From: Steve Tubb [REDACTED]
Sent: 08 July 2022 09:01
To: Harry Chalk <Harry.Chalk@arun.gov.uk>
Subject: Re: FP/59/22/HH - Beach House, Havelock Close

I am the case officer assigned to the above application. I note the plans and application form state that the external alterations are to include render and Cedrai cladding. Has the applicant decided on colorations? I would like to confirm these so as to ensure the finishes are in character with the locality and avoid the addition of any unnecessary conditions.

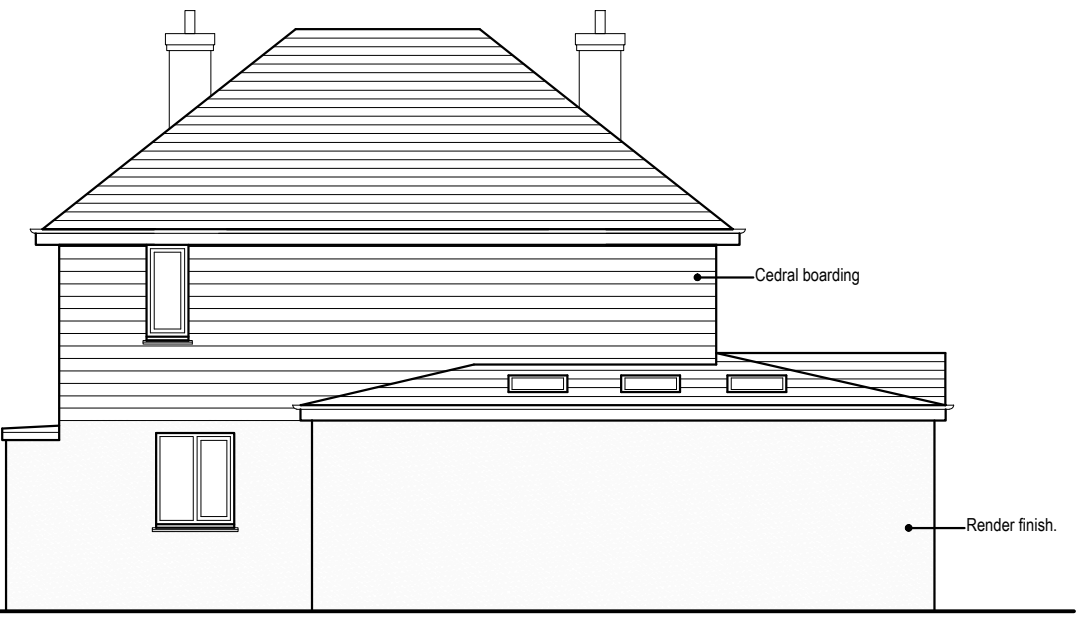
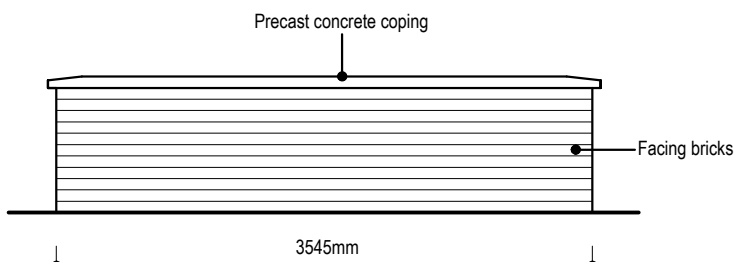
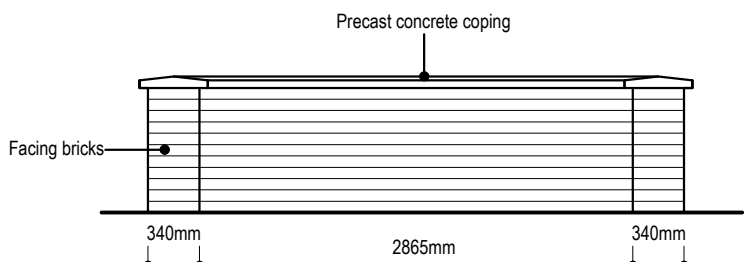
Thanks for that, I will await confirmation. Could I just reiterate I would require the colour of the render also.

I confirm that the cladding colour will be C05 Grey. The render colour will be white.

Colour: Silver Grey [C51].
